**RE: Matthew Drive Storage
3309 Matthew Dr. NW
Grading and Drainage Plan
Engineers Stamp Date 9/28/16 (H16D147)**

DRAINAGE AND TRANSPORTATION INFORMATION SHEET (REV 09/2015)

Based upon the information provided in your submittal received 9/13/16, the above referenced Grading and Drainage plan dated 9/9/16 cannot be approved for Grading Permit or Building Permit until the following comments are addressed:

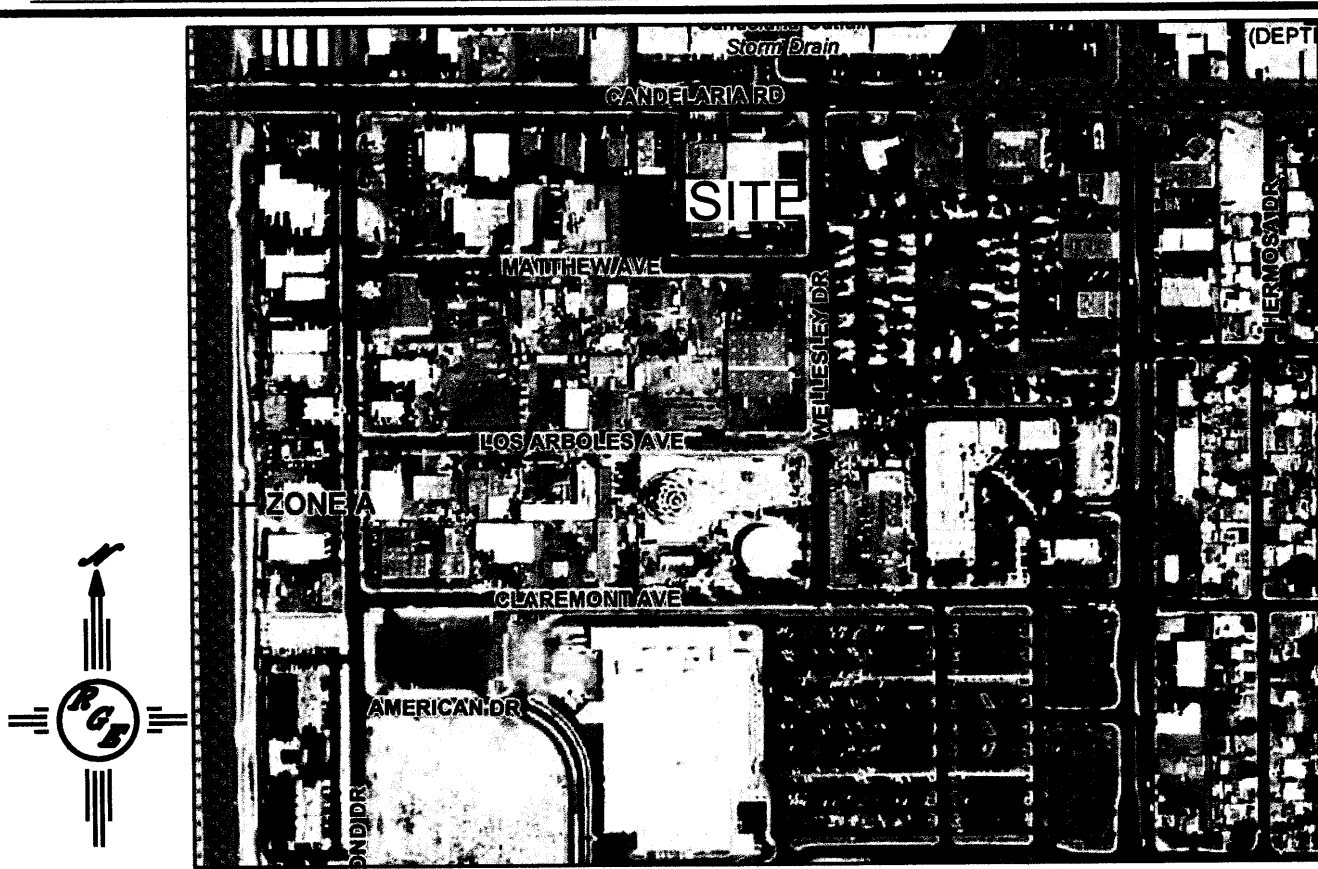
- Enlarge the drainage calcs or provide on a separate sheet with the proper font size. Once submitted the calculations will be checked.
- Provide spot elevations outside the new buildings.
- Statement on sidewalk culvert, add extend passed property line 1 foot.
- Are the landscaping areas new? Is there a curb at the edge of pavement? Is the entire site paved?
- Provide a note in the SO-19 notes stating, to contact Jason Rodriguez at 235-8016 for the sidewalk culvert inspection before and after pouring the concrete.
- Provide a notes stating, The curb stone for the sidewalk culvert must be removed from joint to joint, no cutting.

- Enlarge the drainage calcs or provide on a separate sheet with the proper font size. Once submitted the calculations will be checked.
We have increased scale of the calculations
- Provide spot elevations outside the new buildings.
We have added spots
- Statement on sidewalk culvert, add extend passed property line 1 foot.
We have added note
- Are the landscaping areas new? Is there a curb at the edge of pavement? Is the entire site paved?
The existing site is entirely compacted base course. We are not proposing pavement.
- Provide a note in the SO-19 notes stating, to contact Jason Rodriguez at 235-8016 for the sidewalk culvert inspection before and after pouring the concrete.
We have added Jason's contact information and instructions
- Provide a notes stating, The curb stone for the sidewalk culvert must be removed from joint to joint, no cutting.
We have added this note
